Located At 15 LAWN AVE

Job ID: 2012-11-5409-POOL

has permission to install an above ground pool; no (new) decking.

# MORTGAGE LOAN INSPECTION

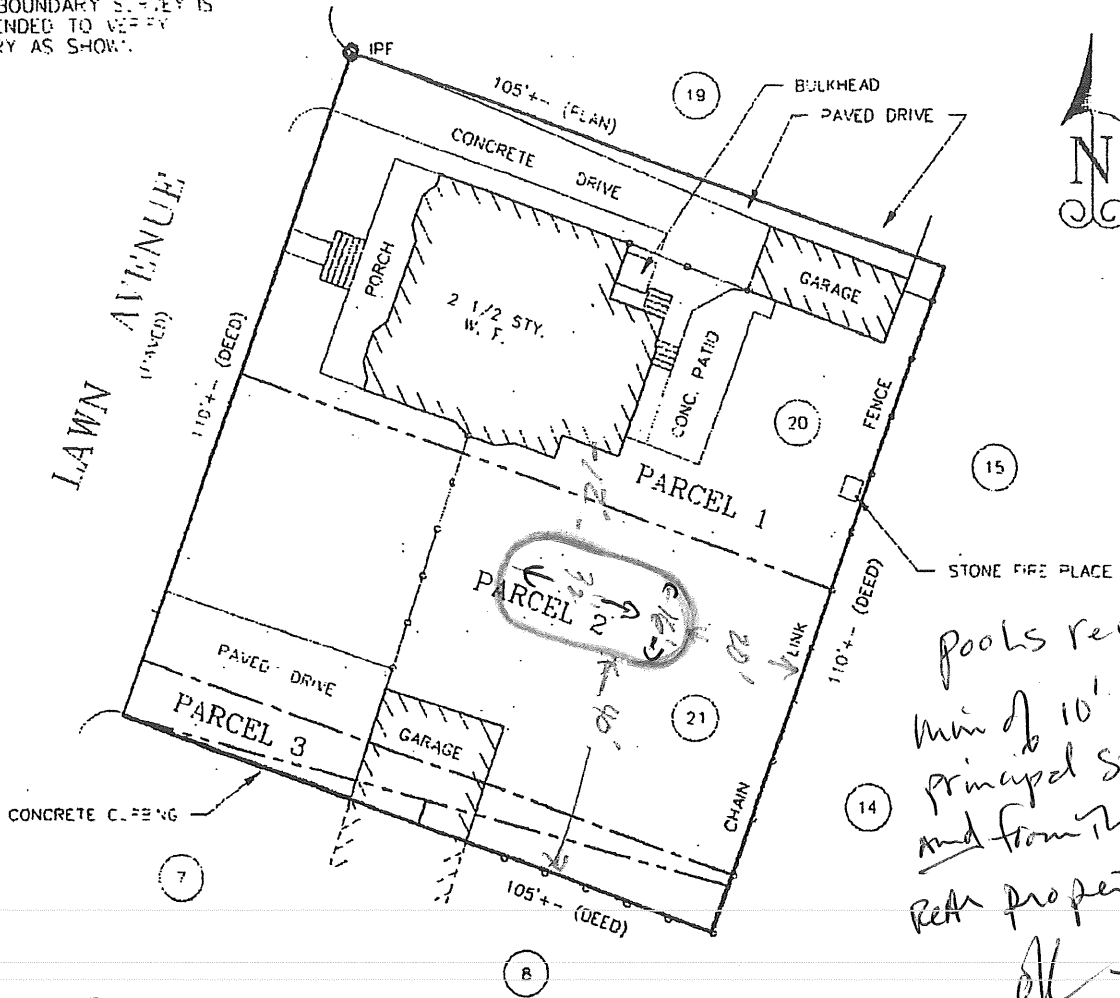
*Handwritten note:*  
Pools require A  
min of 10' from the  
principal structure  
and from the side &  
rear property lines  
OK [Signature]
